23rd May 2018

Attn: Alan Bawden
NSW Rural Fire Service
Customer Service Centre
Coffs Harbour NSW 2450

**RE. Proposed North Byron Parklands Conference Centre and Cabins
Lot 402 and 403 DP 755687, Tweed Valley Way and Jones Road, Yelgun**

Figure 3.2: Proposed Conference Centre Precinct

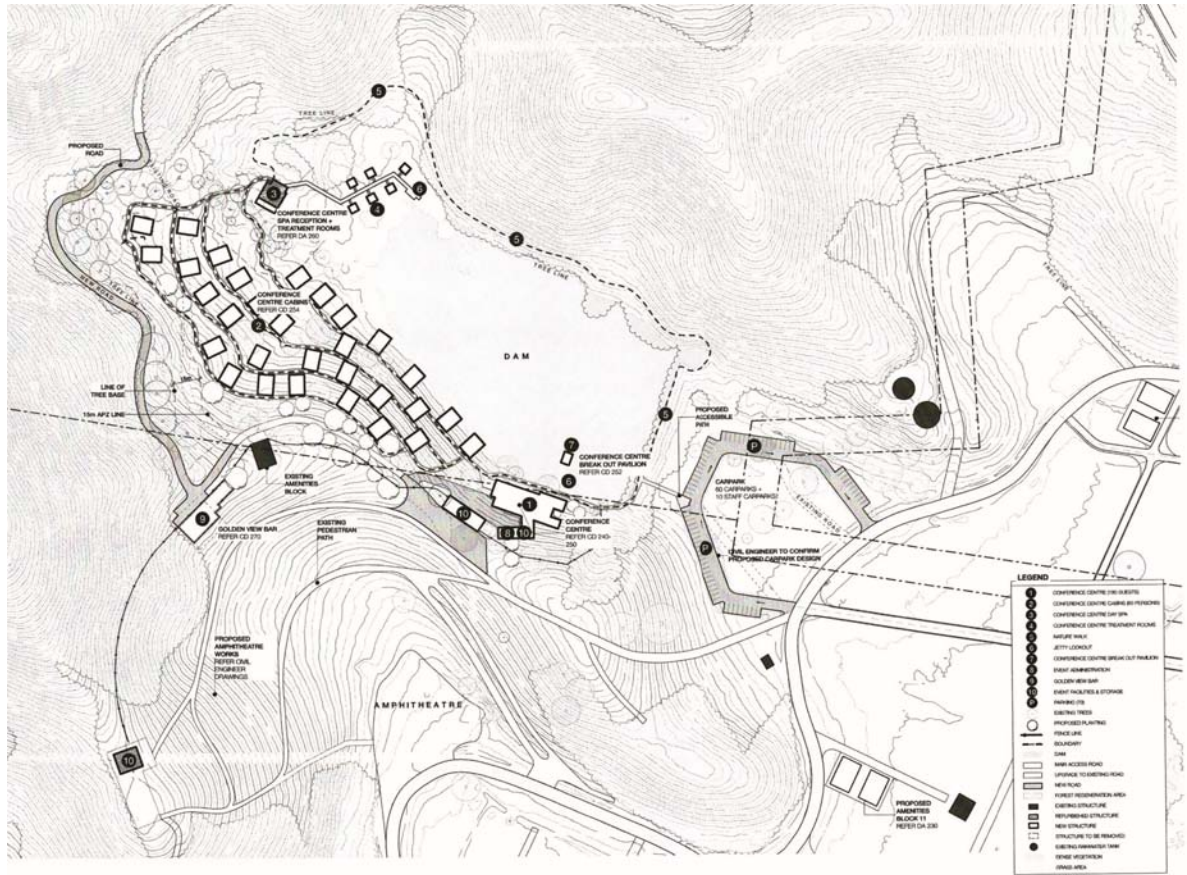
3. The inclusion of the proposed conference centre and cabins does not adequately address the requirements of *Planning for Bush Fire Protection 2006*. The proposed accommodation cabins are classified as Special Fire Protection Purpose development under S100B of the *Rural Fires Act 1997*. The accompanying bush fire report does not adequately justify why the proposed cabins cannot achieve a maximum 10 kW radiant heat exposure. The report does not provide adequate justification that the identified bush fire hazard cannot be managed or the cabins can be relocated further away from the identified bush fire hazard.

The performance solution establishes with evacuation planning, the performance criteria will be achieved to allow occupants and emergency services to not experience greater than 10kW/m² when exiting or entering a building.

This concept is not dissimilar to evacuation planning undertaken in a single building through a designated exit or horizontal exits in the case of aged care and hospital where the exit will not receive greater than 10kW/m². The methodology is also consistent with the NSW RFS Fast Fact 1/14 which considers this approach as satisfying occupant and emergency service safety during a bushfire event irrespective of the business model for the development (ecotourism).
